Application for a non-material amendment following a grant of planning permission.

Erection of a new two-storey, six classroom block	
Reference number:	H09-0838-19
Date of decision	25/11/2019

Elevation Changes:-
- Omission of Brise Soleil
- Addition of PV array to roof
- Rationalise extents curtain walling
- Addition of canopy over main entrance

Proposed Plans & Elevations

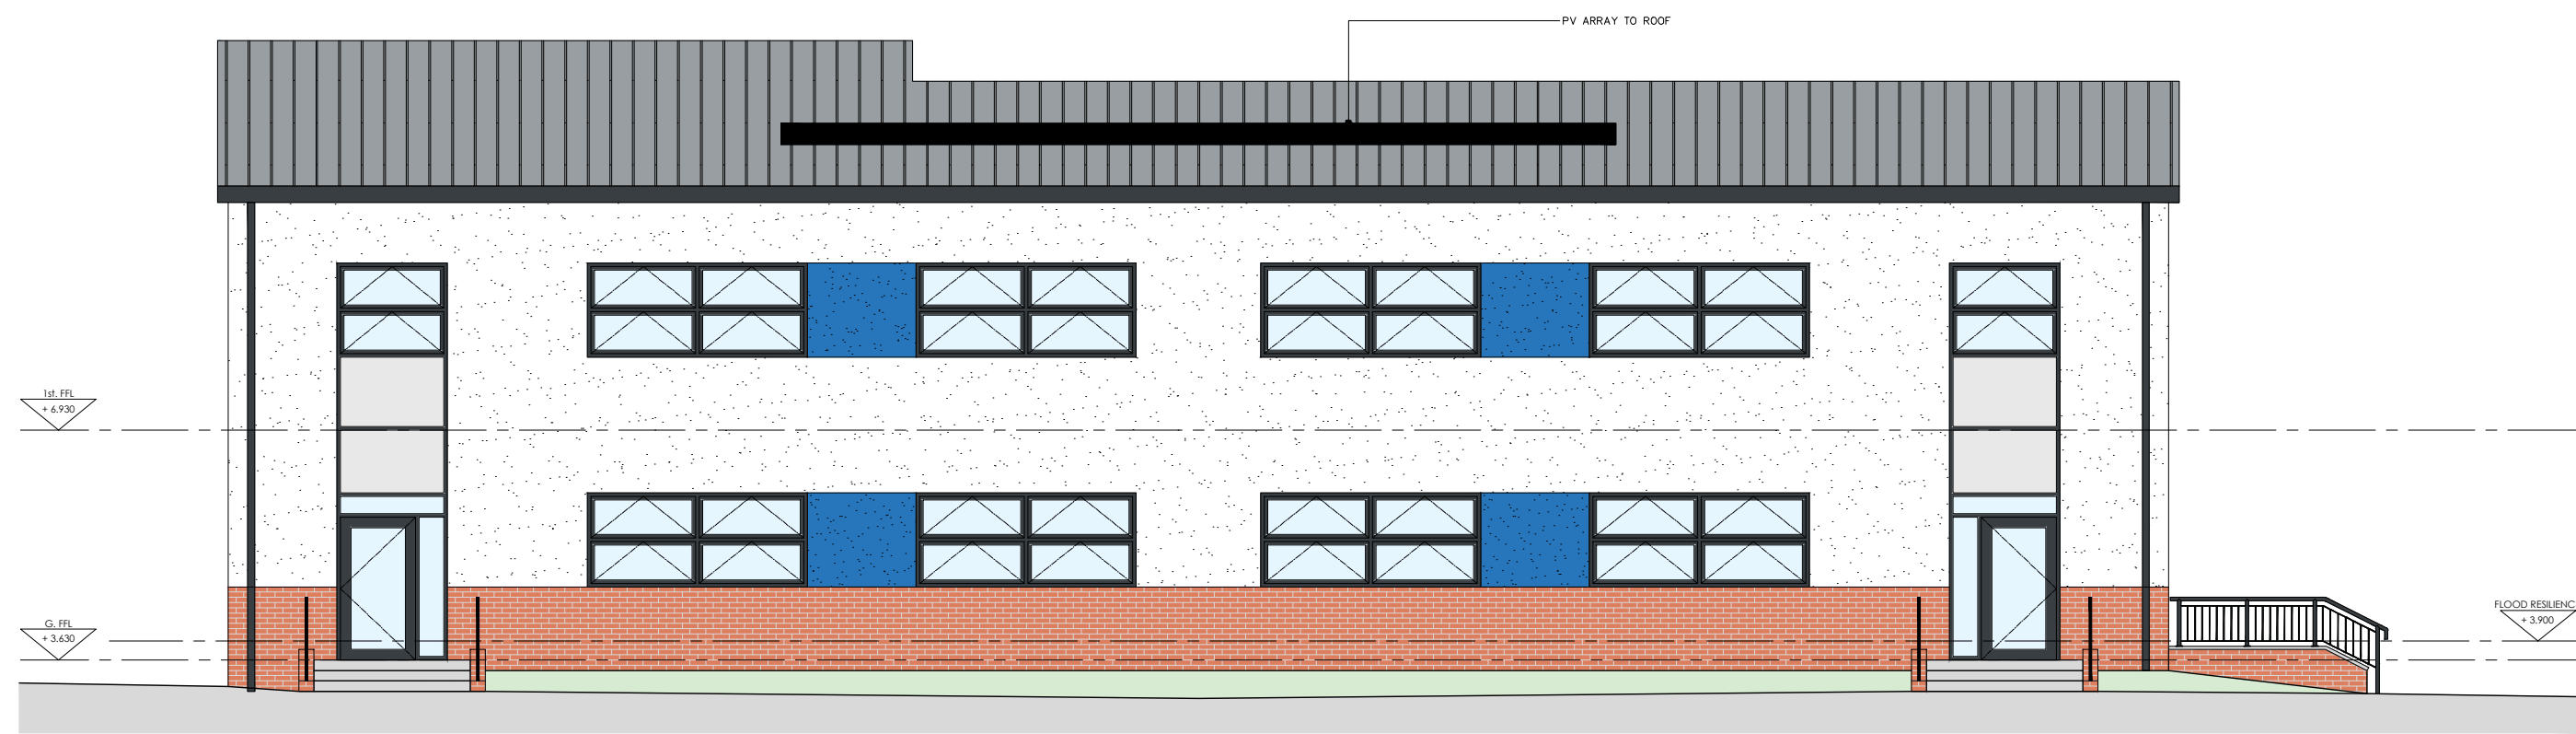
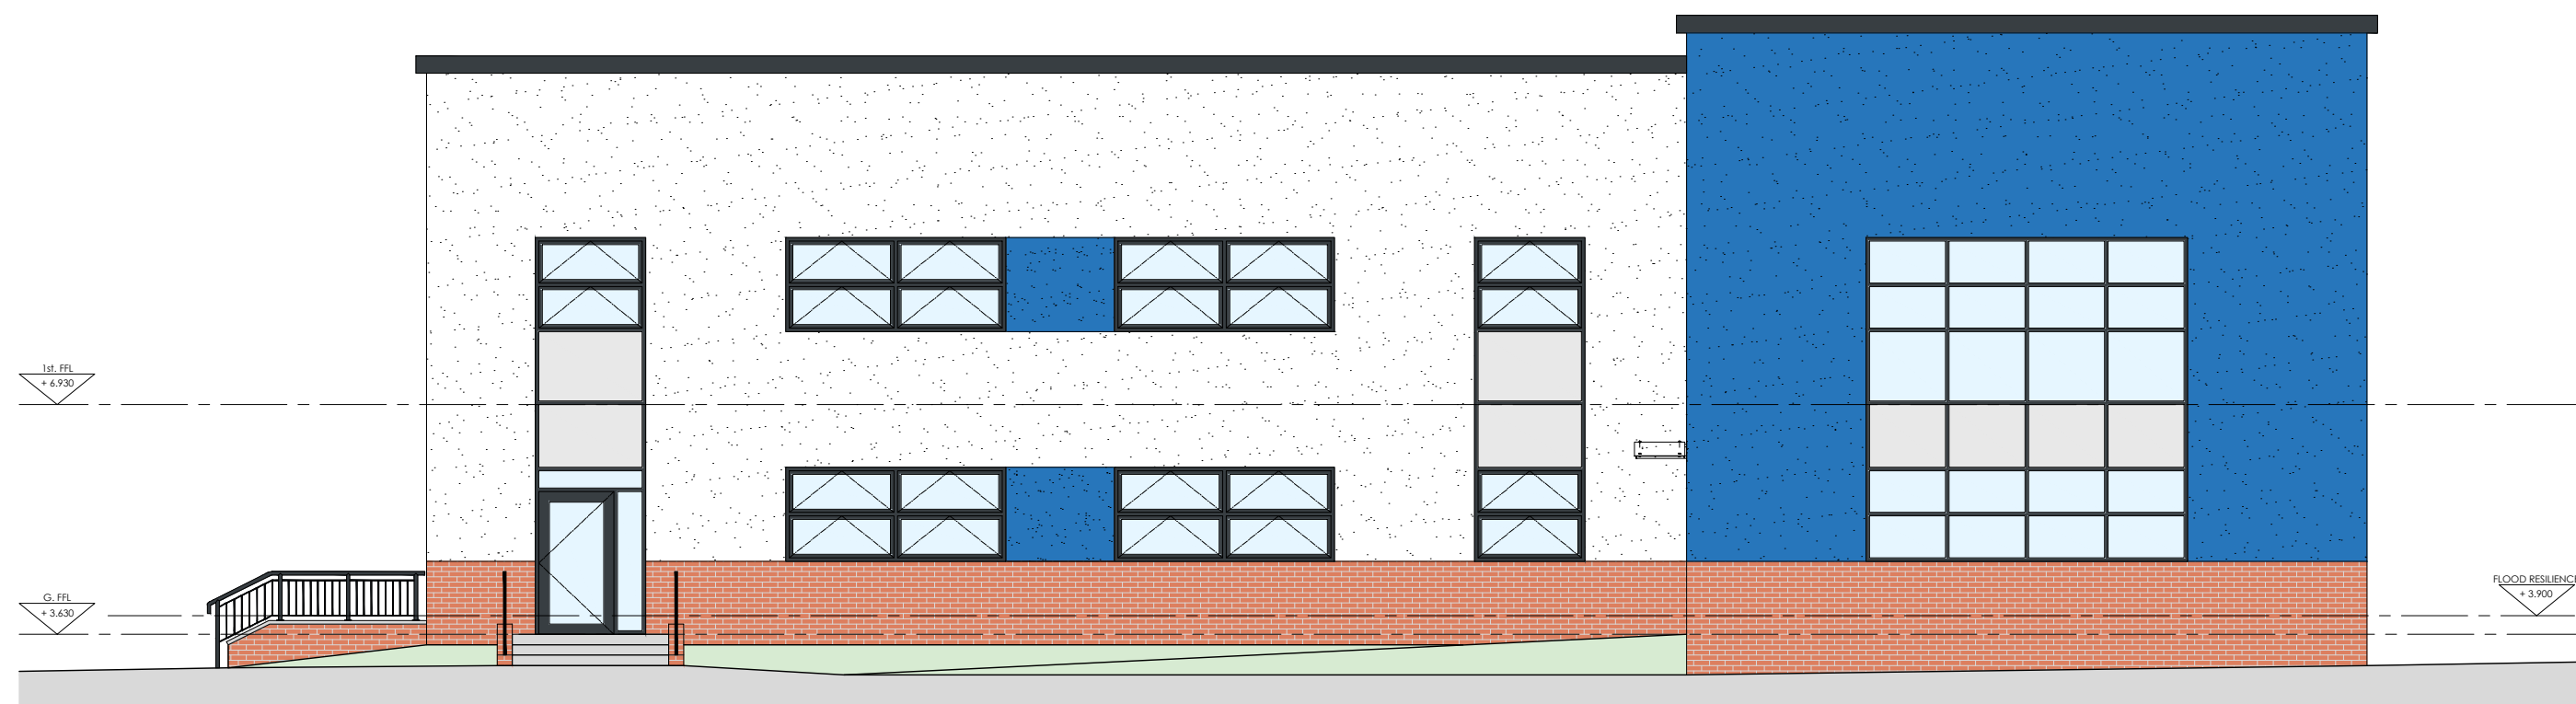
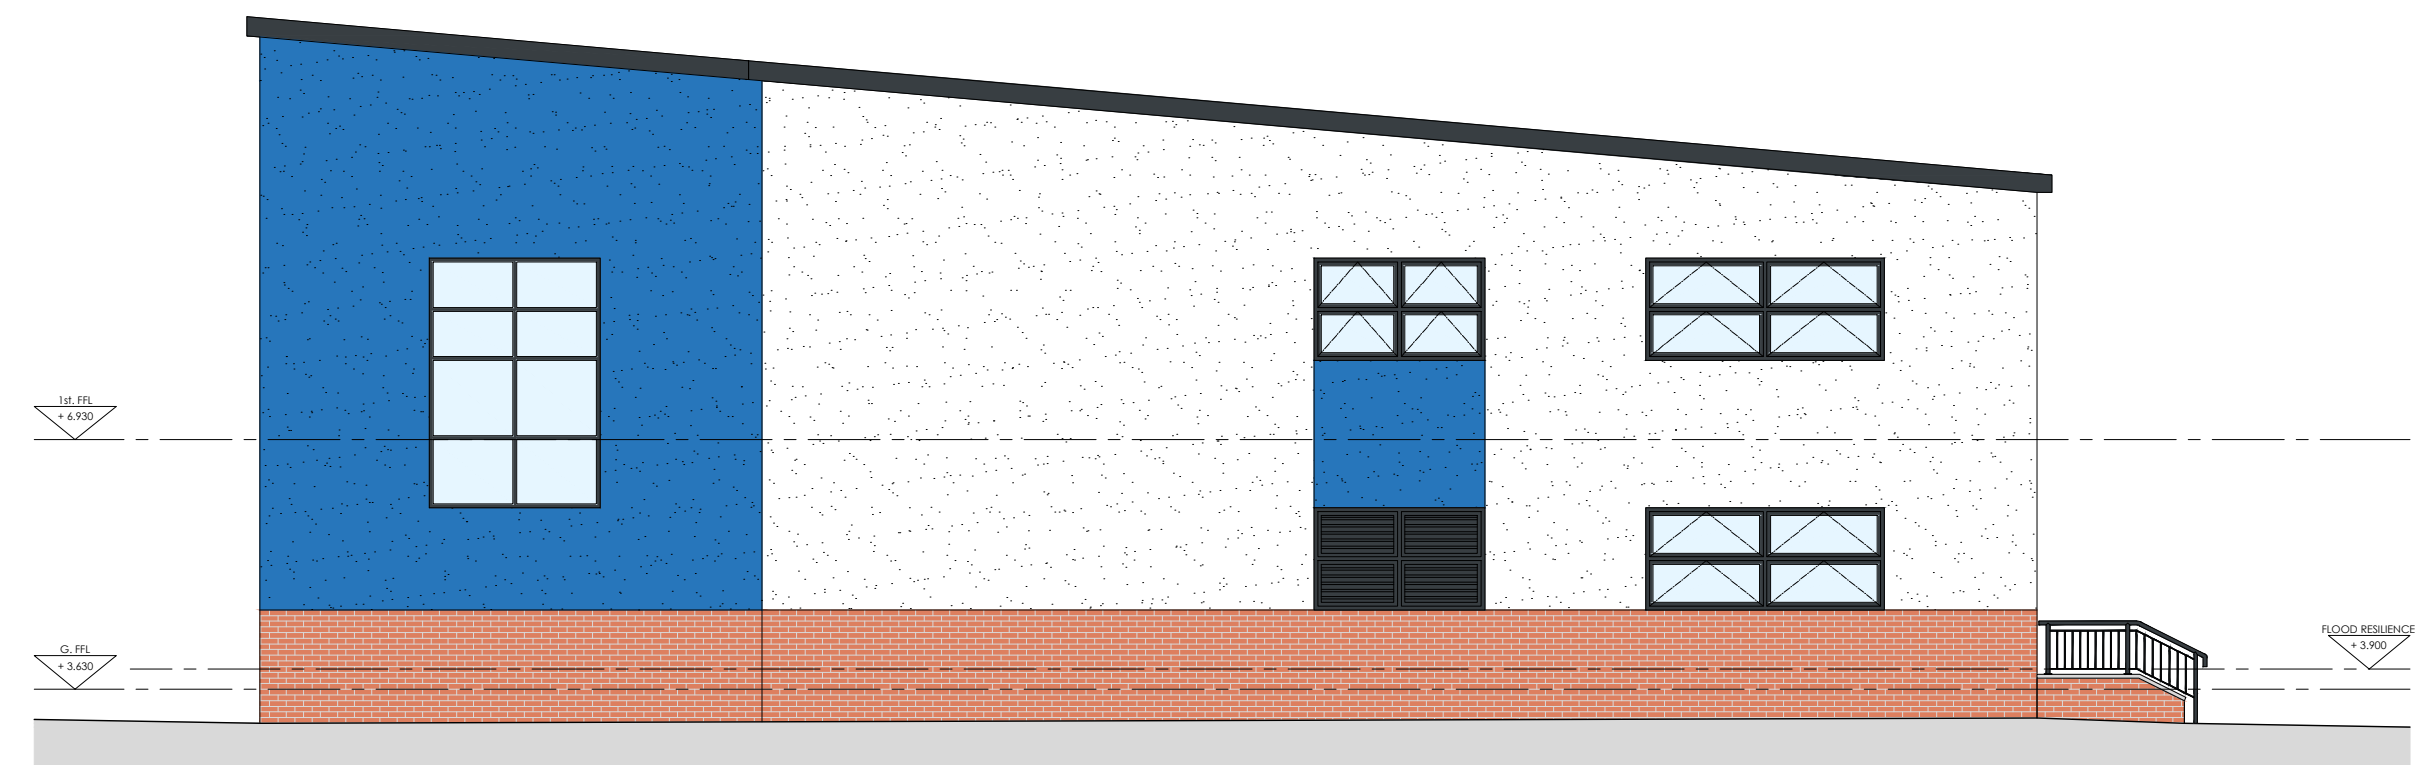
Brise Soleil omitted, PV added and extent of curtain walling reduced to comply with SBEM, canopy added over principle entrance as required for Building Regulations
